**KIRKLEES METROPOLITAN COUNCIL
INVESTMENT & REGENERATION SERVICE**

DELEGATED DECISION TO DETERMINE PLANNING APPLICATIONS

Reference No:	2025/62/92322/W
Site Address:	6, Honey Head Lane, Honley, Holmfirth, HD9 6RW
Description:	Erection of first floor extension to side elevation and dormer extension with associated alterations
Recommending Officer:	Joshua Merriman

HOUSEHOLDER DELEGATED REPORT

Date created 08/04/25	Client Name Mr & Mrs A Short		
Approved by: --	Project 6 Honey Head Lane	Project number: 2024.00105.000	
Drawn by: MS	Title: Combined Proposed GA Floor Plans and Elevations		
Scale: 1 : 100 @ A2	Drawing number 6HH-STE-XX-ZZ-DR-A-20002	Status: PL	Revision: P01

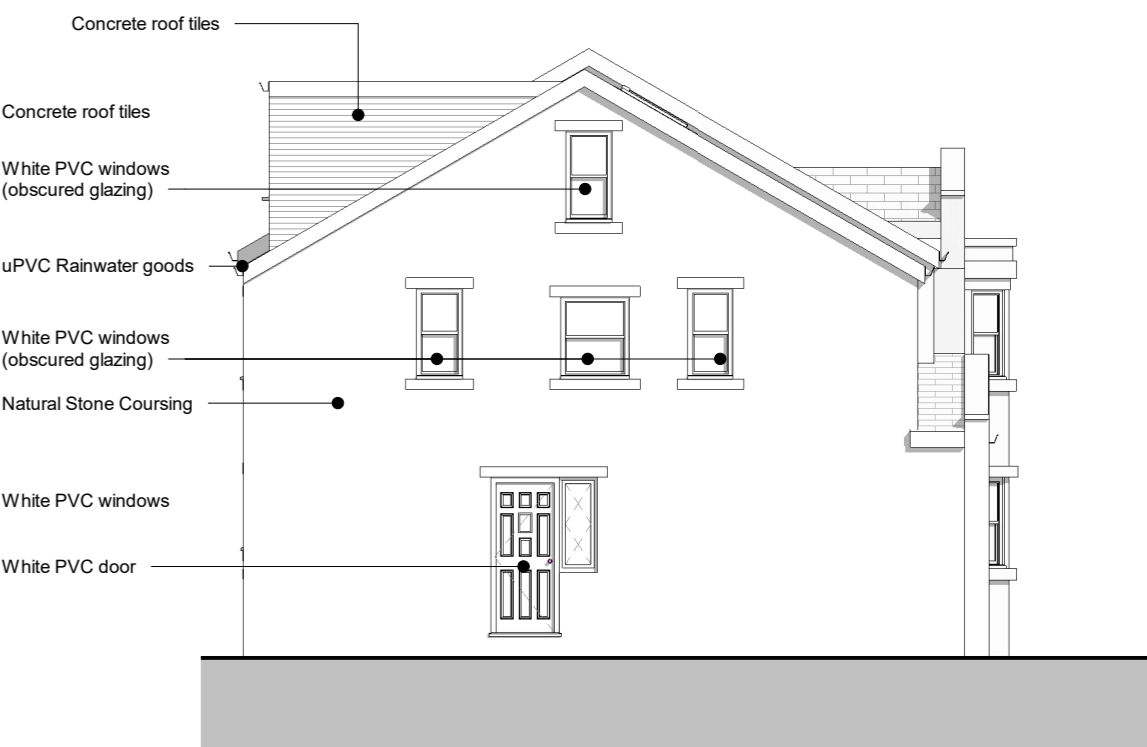
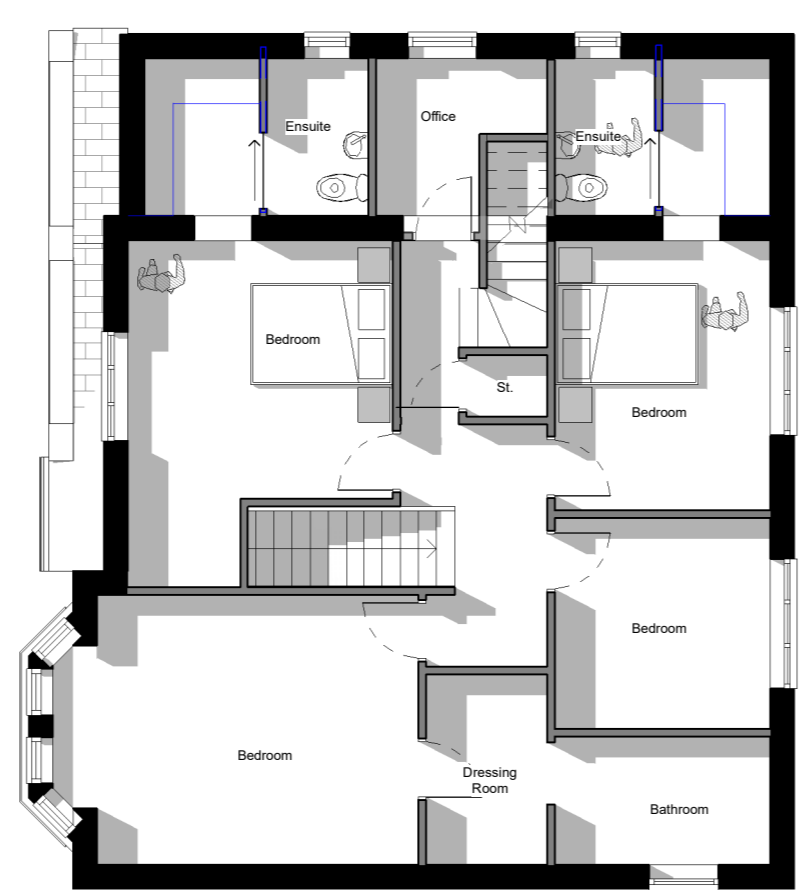
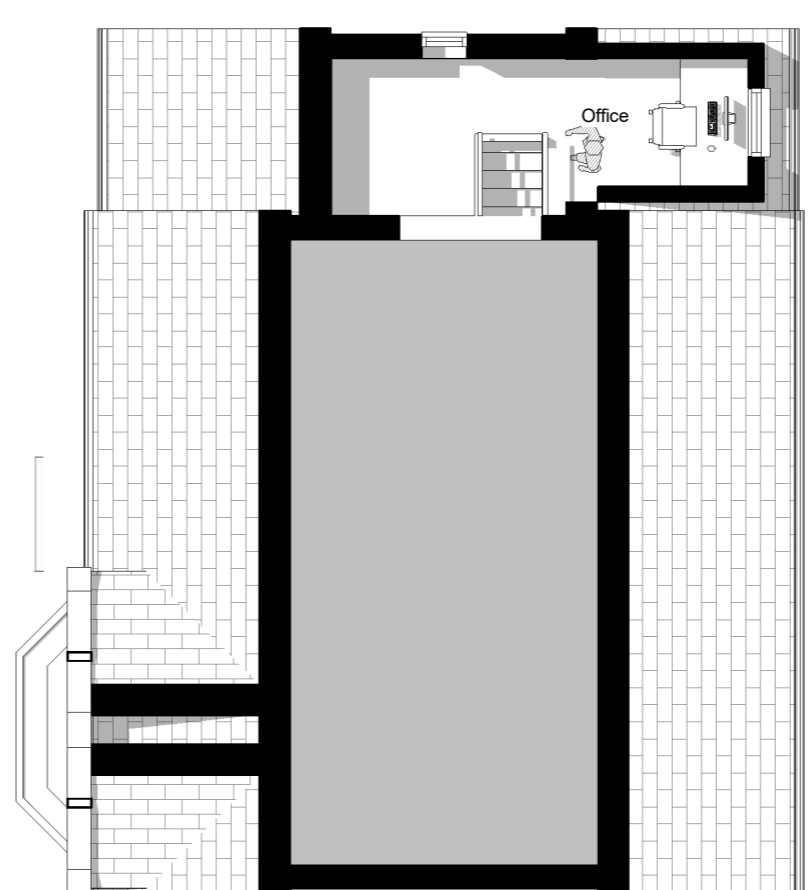
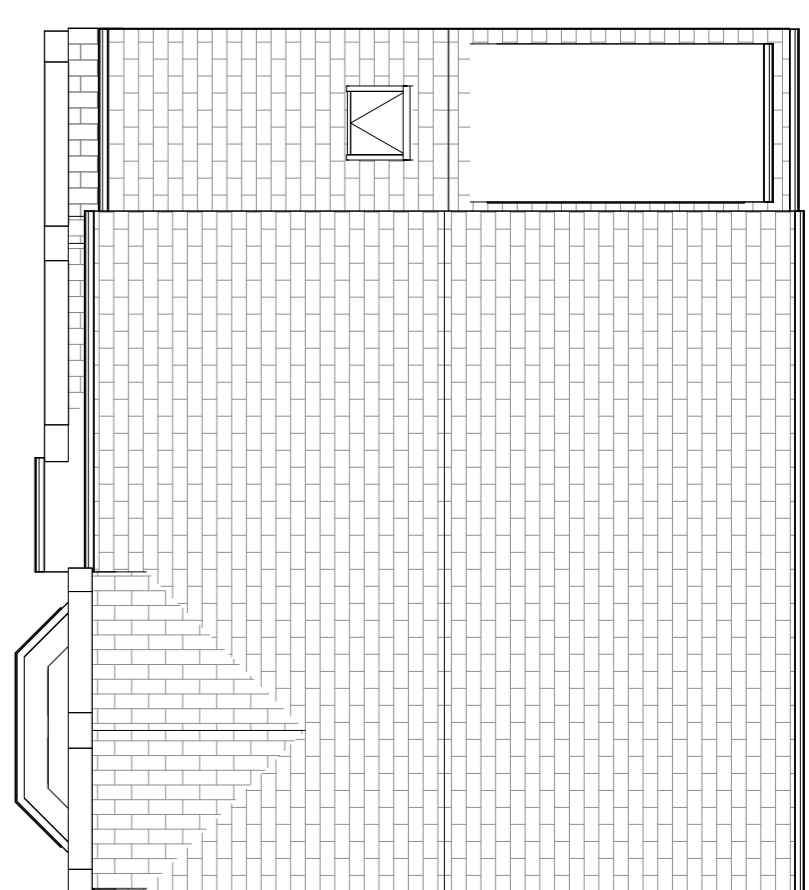
The proposed first floor side extension will project 2.48m from the side elevation of the existing first floor, not projecting beyond the current side elevation of the ground floor of the property, with a maximum height of 7.68m, eaves height of 4.82m, and a depth of 8.93m.

The proposed rear dormer will project a maximum of 3.87m from the roof of the property, with a maximum height of 2.24m, eaves height of 2.02m, and a width of 2.09m.

be set back at least 500mm from the front wall of the house		The proposal is set back approx. 200mm from the front wall of the original house. Whilst this falls short of the required 500mm, as the extension is set back slightly, with the eaves and ridge set lower than those on the main property. It will appear subservient to the main property and is therefore acceptable.
Dormer extensions should:	<u>Yes - COMPLY</u>	<u>No - JUSTIFY</u>
relate to the appearance of the house and existing roof	The dormer will be faced in materials that either match, or are sympathetic to, the existing building and roof.	
be designed in style and materials similar to the appearance of the existing house and roof	The extension is to be designed in style and materials similar to the appearance of the existing house and roof.	
not dominate the roof or project above the ridge of the house	The dormer is will be set within the roofscape of the proposed first floor side extension to the rear and is considered a small addition and is therefore not considered to dominate the roof of the existing building, or does not project above the ridge of the house.

be set below the ridgeline of the existing roof and within the roof plane	The dormer is proposed to be set below the ridgeline of the existing roof and entirely within the roof plane.	
be aligned with existing dormer windows on neighbouring properties	There are no neighbouring dormer windows to align with, however, it is

3. The external walls and roofing materials of the first floor side extension approved shall in all respects match those used in the construction of the existing building, with a flat roof to the proposed dormer extension also being considered acceptable.

4. The face and cheeks of the dormer hereby approved shall be faced in vertically hung tiles which shall in all respects match those used in the construction of the existing building. The dormer shall thereafter be retained with this finish.
